Re: **Marysville Corporate Center**
BSP File# PA22-004
Project Number 2200444.00

In response to your plan review checklist dated September 1, 2022, we have addressed the items below, with our responses following your comments.

SHEET 3 OF 4

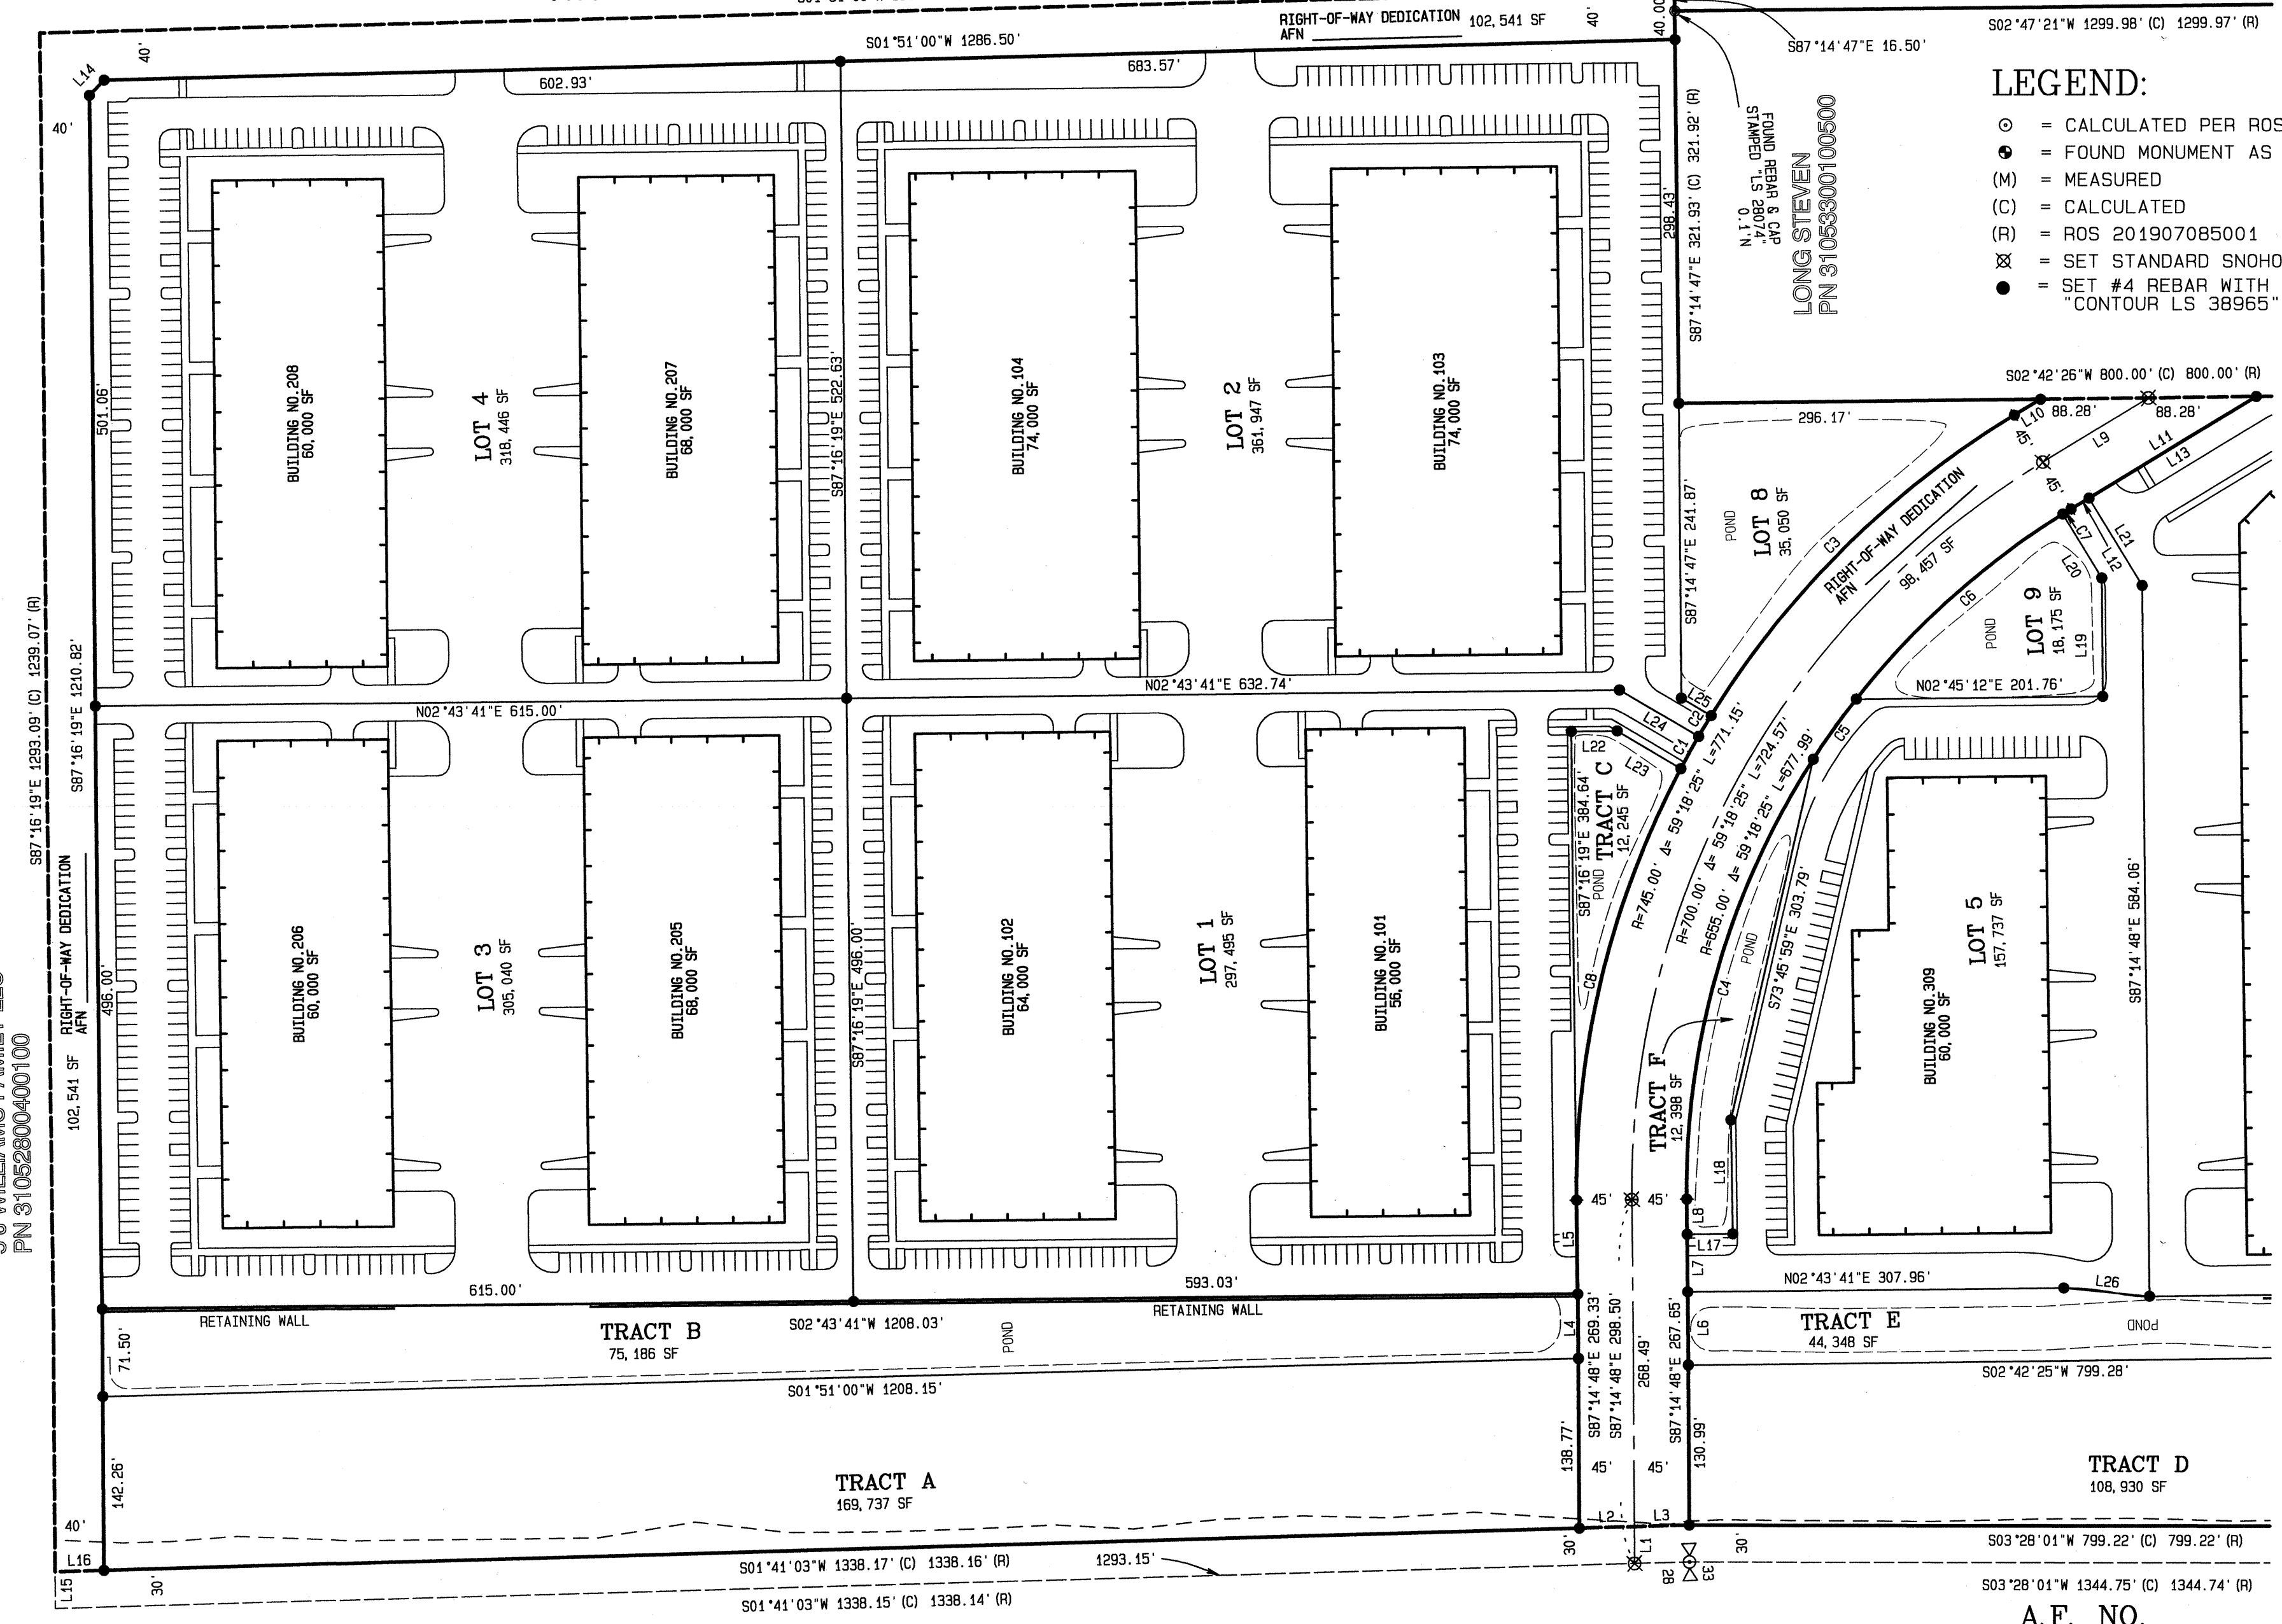
- a. *156th Street NE will require a 90 foot dedication.*
- b. *Provided that a half street type designed is allowed, it would appear that a 42 foot dedication would be necessary for half street construction of 160th Street NE.*
- c. *47th Ave NE will need to have 35 feet of dedication. If the multi-use path is on the west side of the road a 40 foot dedication will be required. The alignment of the dedication at the south end of 47th will need to start sweeping to the west to align with what I previously provided. Let me know if you need the drawing for reference.*

Response: As shown on the BSP, 44' will be dedicated on both 160th and 47th. Adequacy of the 44' width is illustrated on the site development and road way plans (G22-0040).
